April 30, 1986

RE: DRAINAGE PLAN FOR CASA FELICITA APARTMENTS PHASE I
(J-14/D&I) REVISION DATE APRIL 16, 1986

RE: DRAINAGE PLAN FOR CASA FELICITA APARTMENTS (J-14/D61)
RECEIVED APRIL 9, 1986

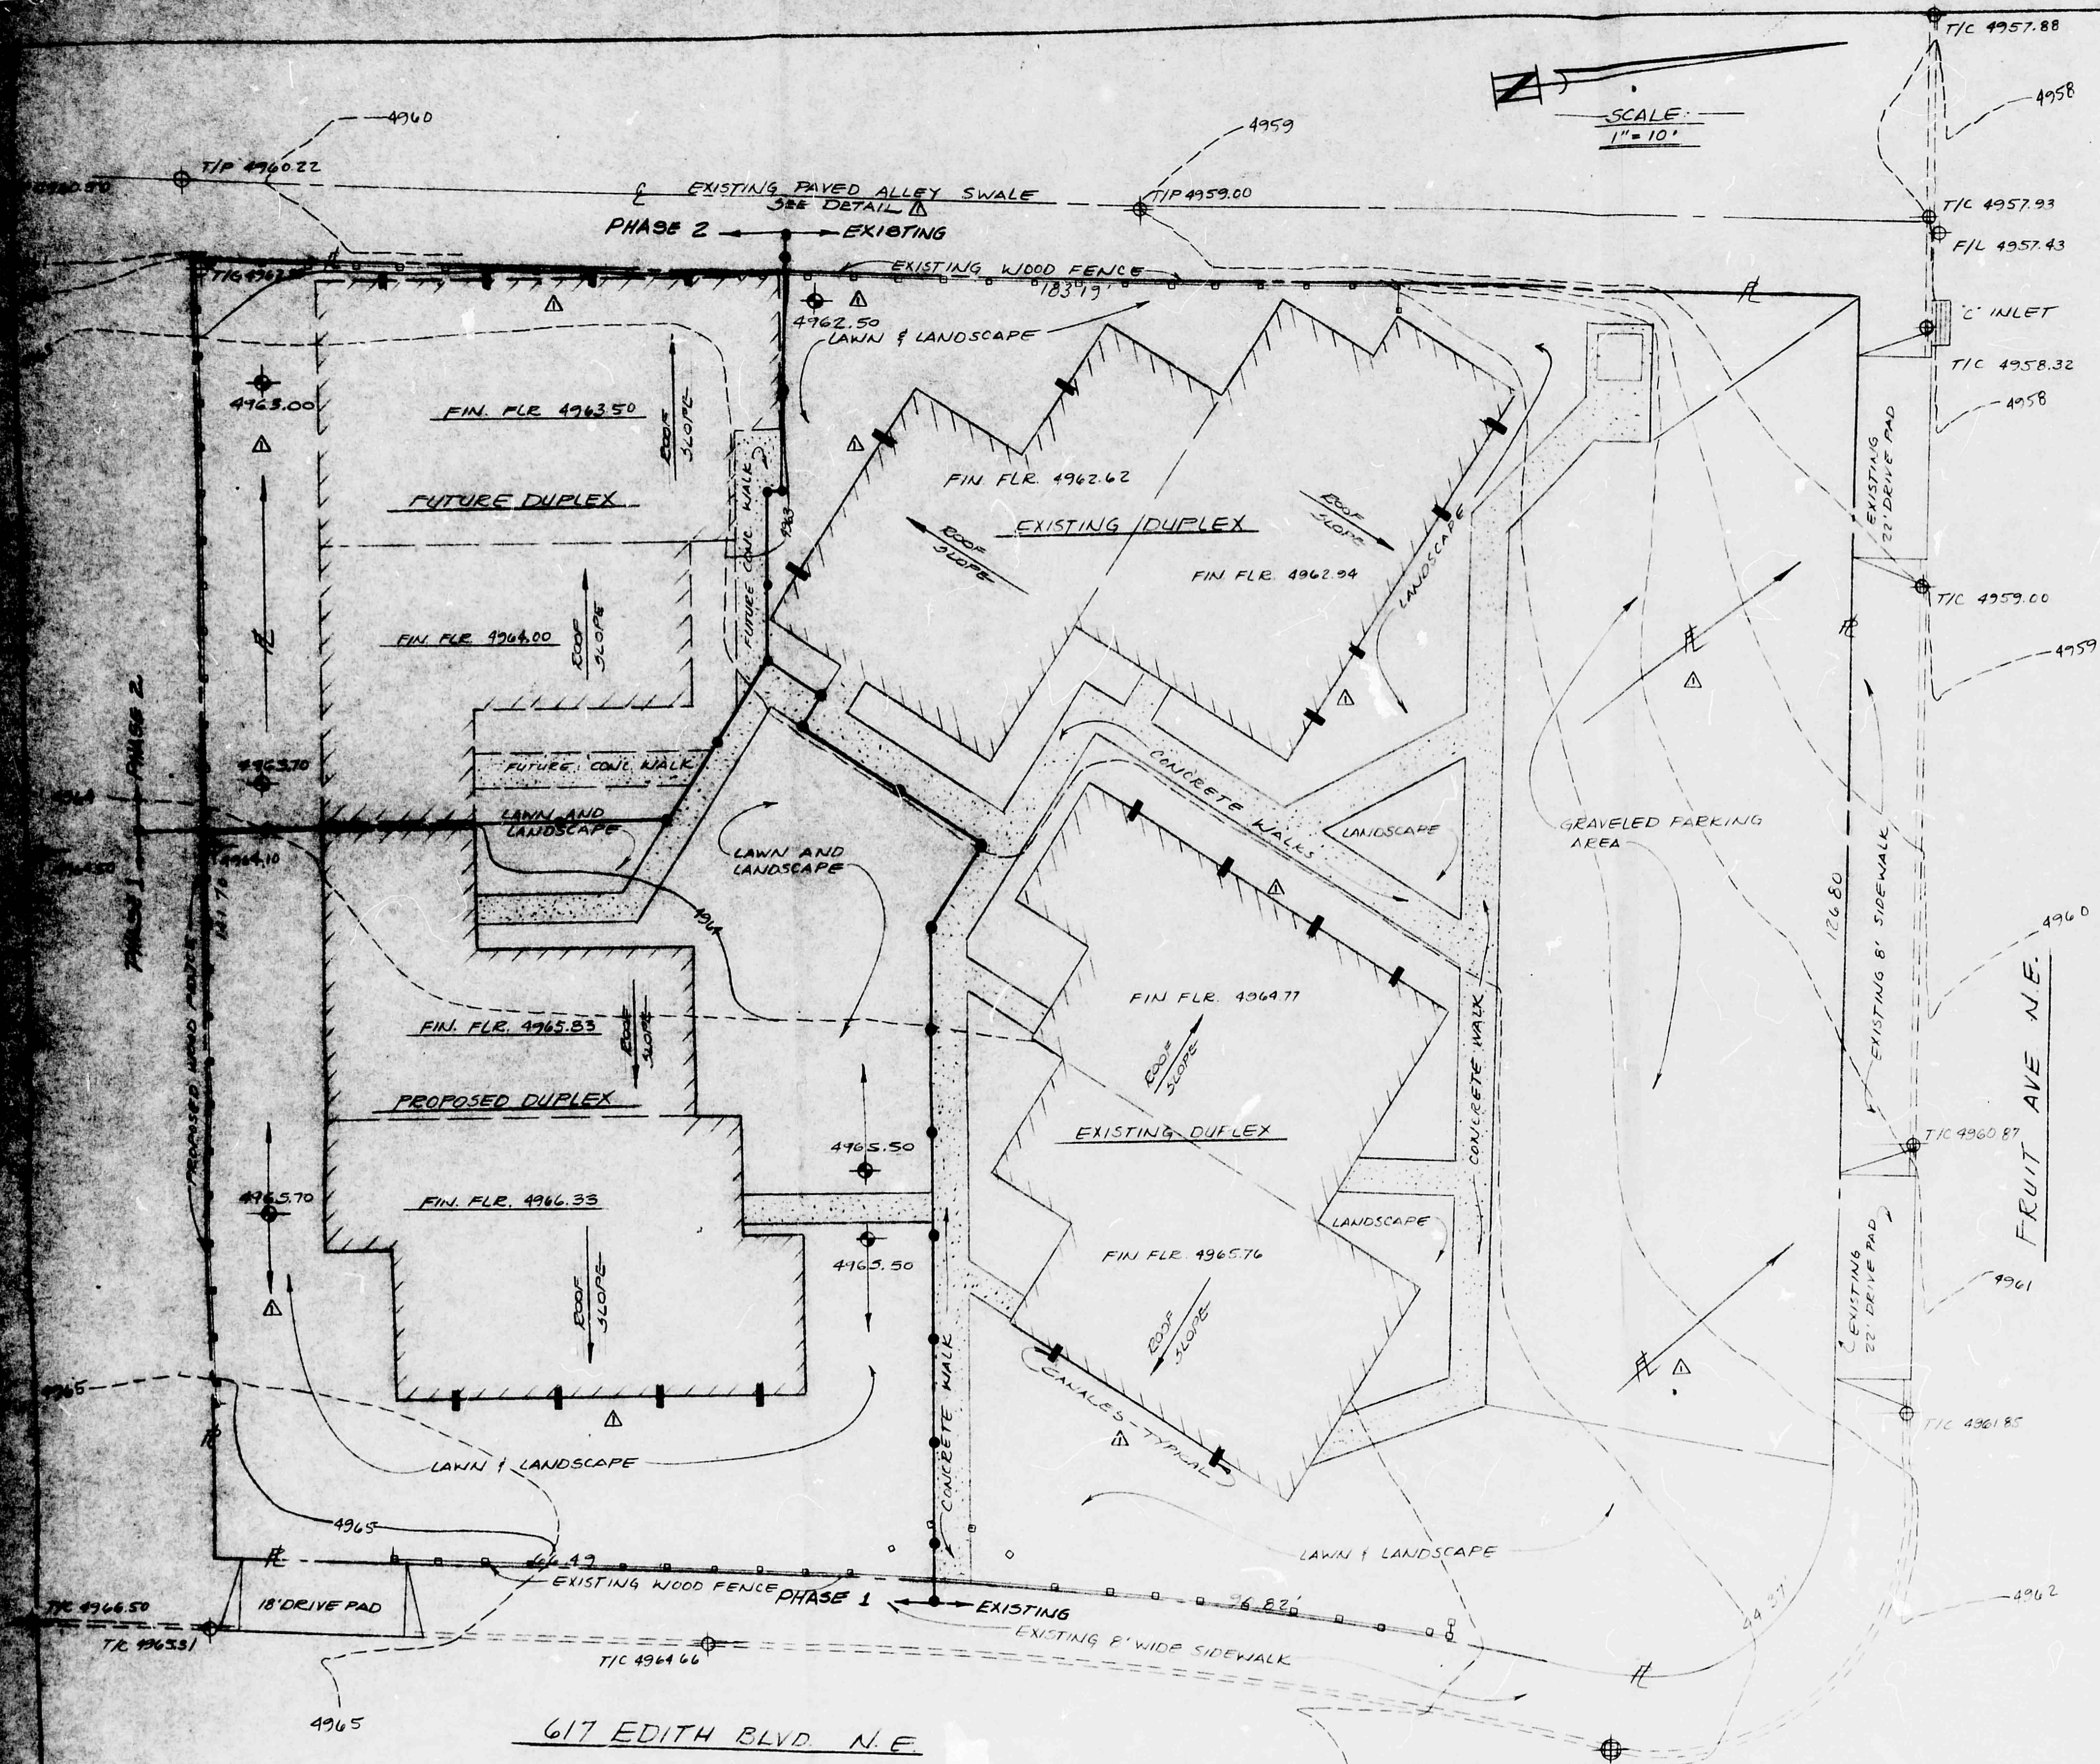
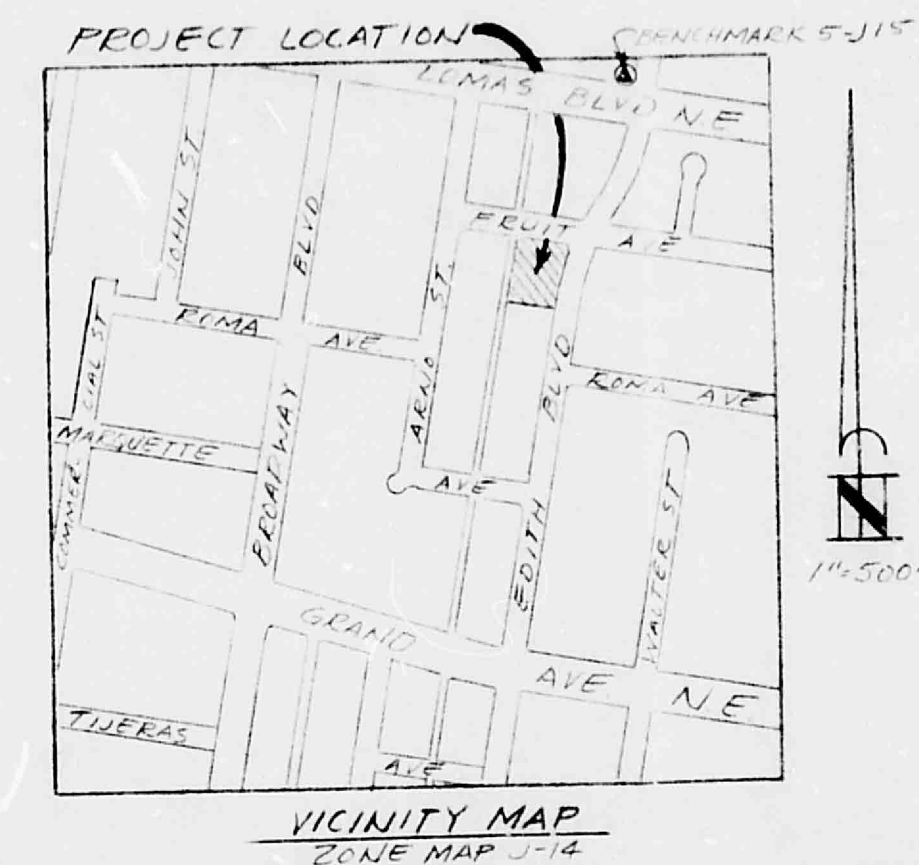
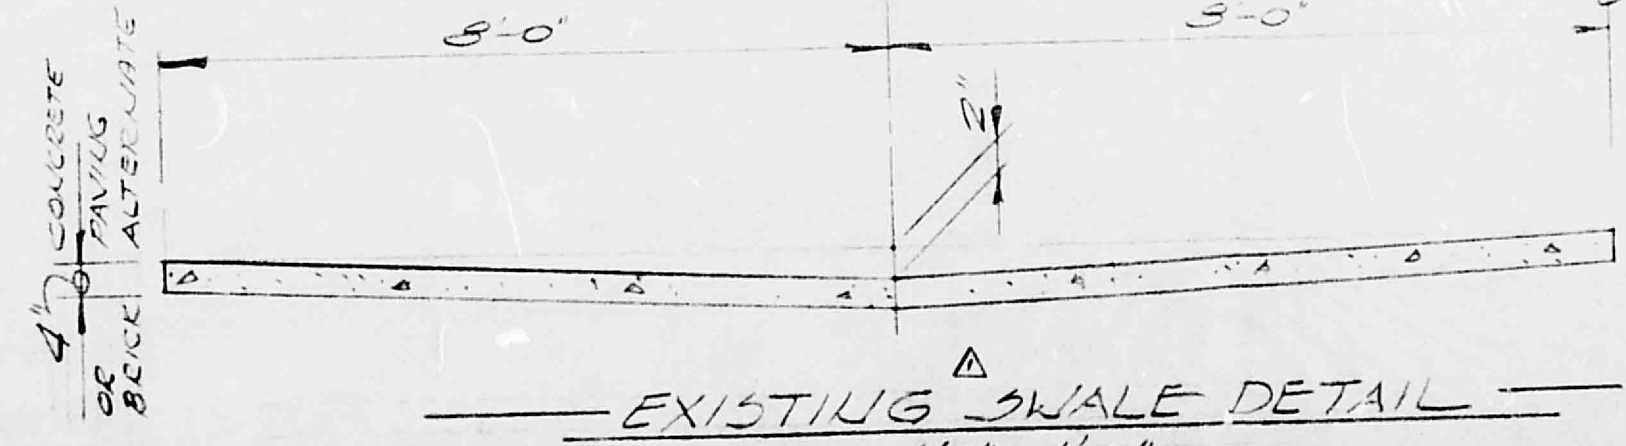
1. Location of B.M., TBM must be identified as a curb notch or painted.
2. Location and direction of roof drains.
3. More spot elevations to show where developed run-off is supposed to go.
4. Swale detail.
5. Please identify what methods the contractor might use to control erosion.

Based on the information provided on your April 17, 1986 resubmittal, the above referenced drainage plan is approved for Building Permit.
